**Our Case Number:** ABP-318802-24

**Re:** Proposed development of a resource recovery centre (including waste-to-energy facility)  
in Ringaskiddy, County Cork.

**OBSERVATION ON SID APPLICATION – Case reference PA04.318802, Ringaskiddy, Co. Cork.**

By Indaver NV t/a Indaver Ireland

Figure 8.4 Cork Airport Windrose 2021 -2025

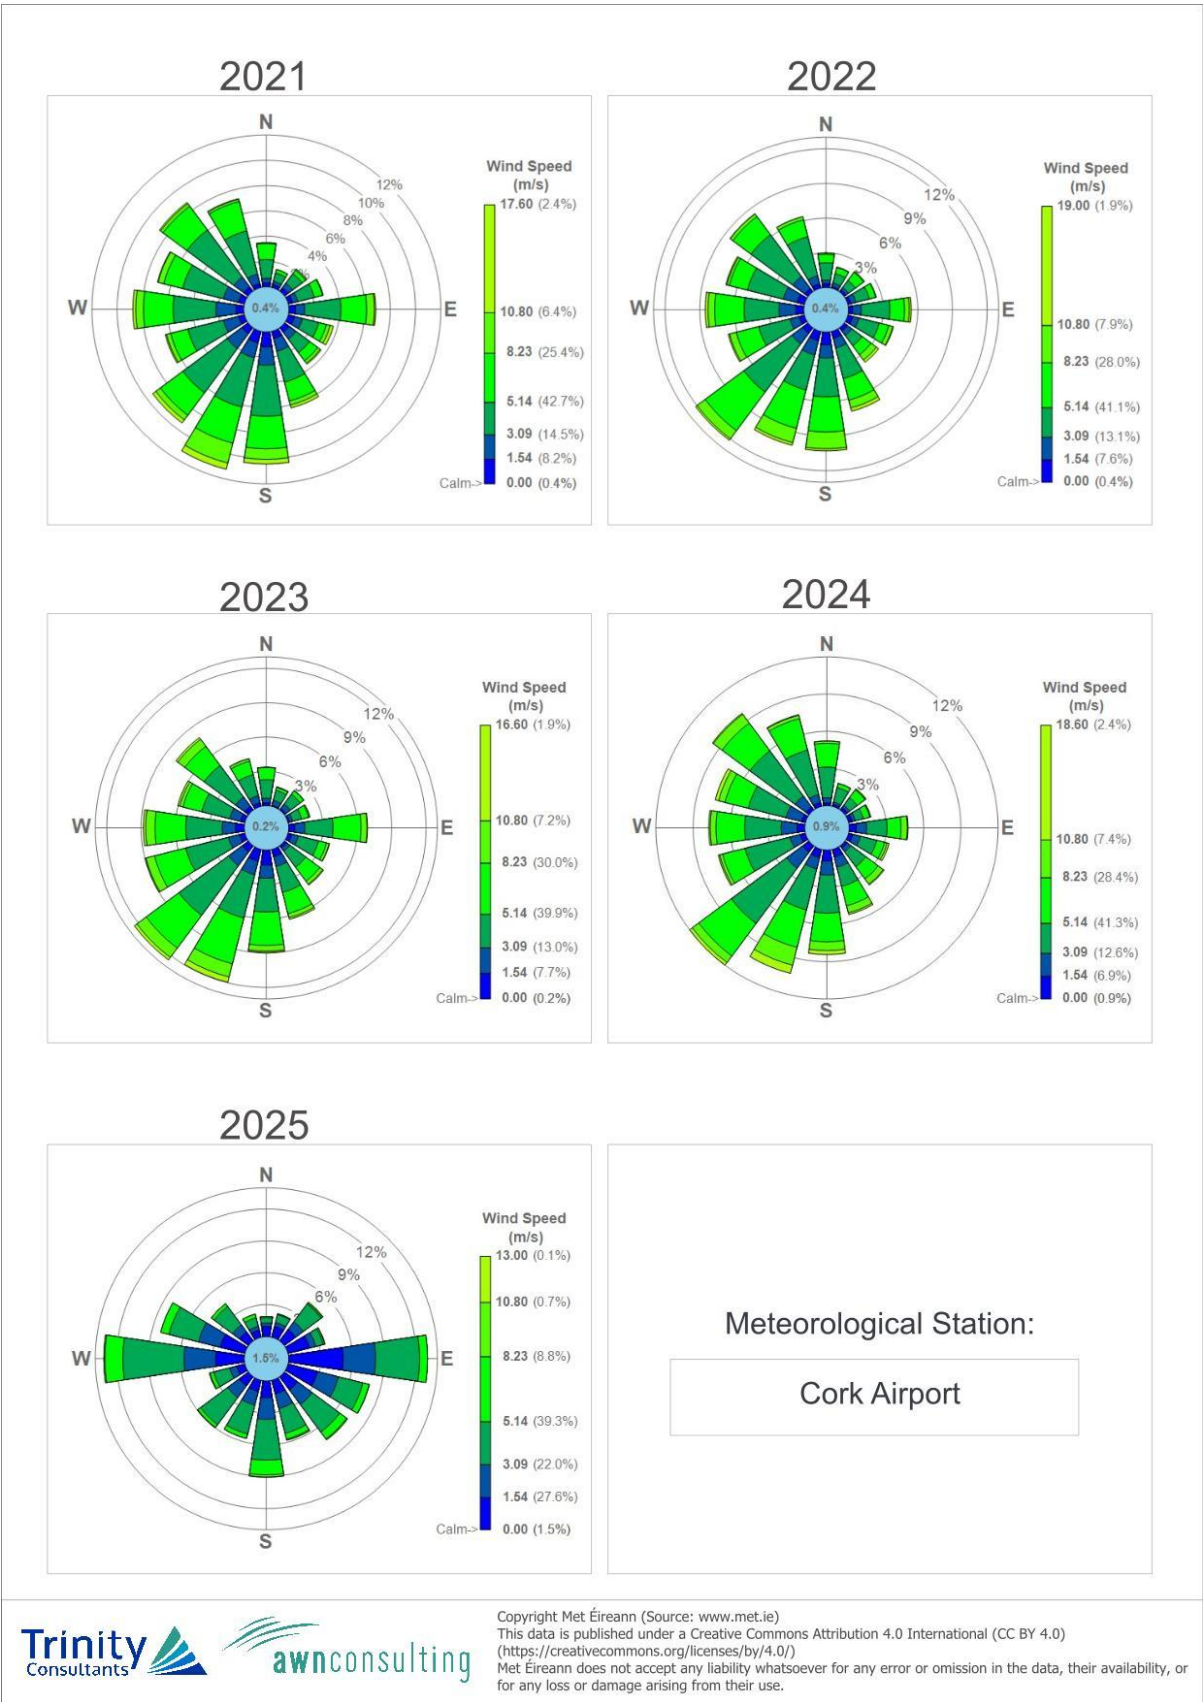
The primary meteorological input data for the air dispersion modelling is sourced from the Cork Airport Met Éireann weather station, which is approximately 12 km from the proposed development site and situated about 150 m above sea level—roughly 80 m higher than the proposed chimney stack outlet. It is concerning to note in Appendix 8.1 – Section 8.3.2.3 that *“Calm conditions account for only a small fraction of the time in any one year, peaking at 31 hours in 2021 (0.4% of the time)”*.

In my experience, calm or near-calm conditions occur far more frequently at the proposed incinerator site than indicated by the wind speed data used for the Air Dispersion Modelling (as provided in Appendix 8.2). Such conditions would likely present a more adverse scenario for Air Dispersion Modelling, as reduced wind speeds significantly limit pollutant dispersion and increase ground-level concentrations.

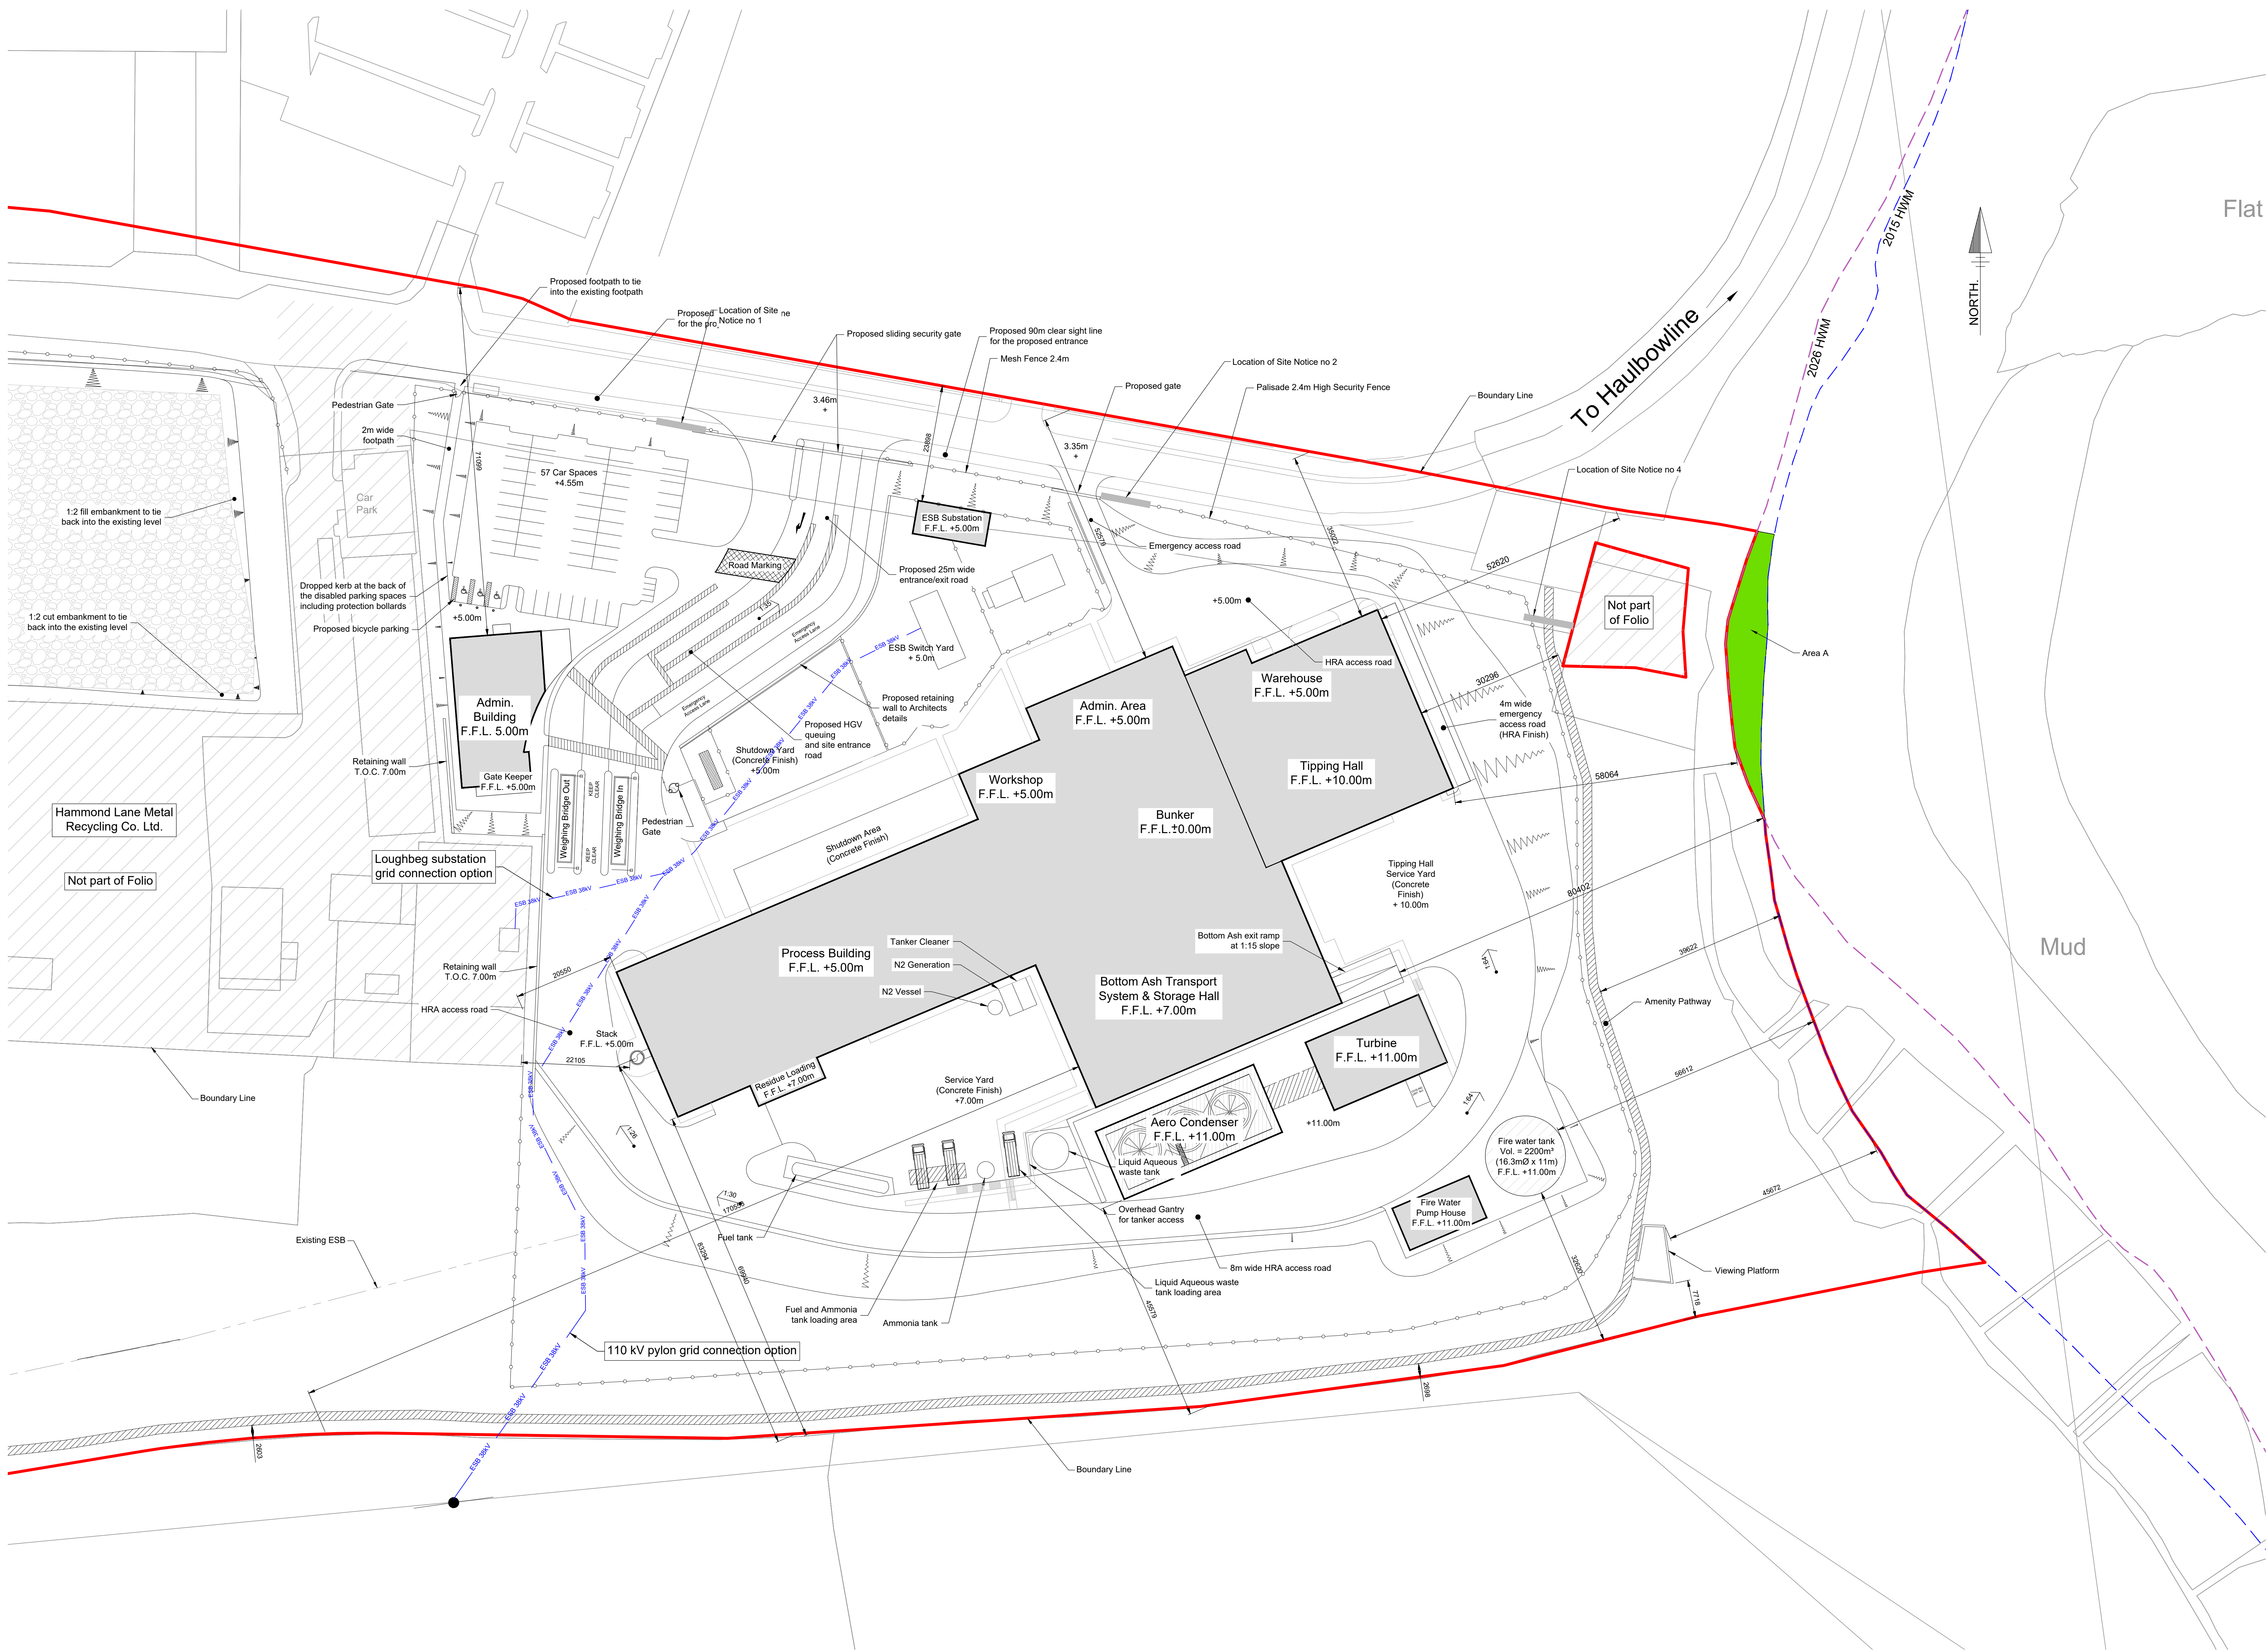
The planning drawings for the "Raised Plateau Level" at the western end of the site—referred to as the Western Fields—are unclear in the submission. This appears to be a significant engineered platform with vehicular access from the public road. The intended purpose of this area should be explicitly stated on the planning drawings to ensure transparency and allow for proper assessment of its function within the overall development.
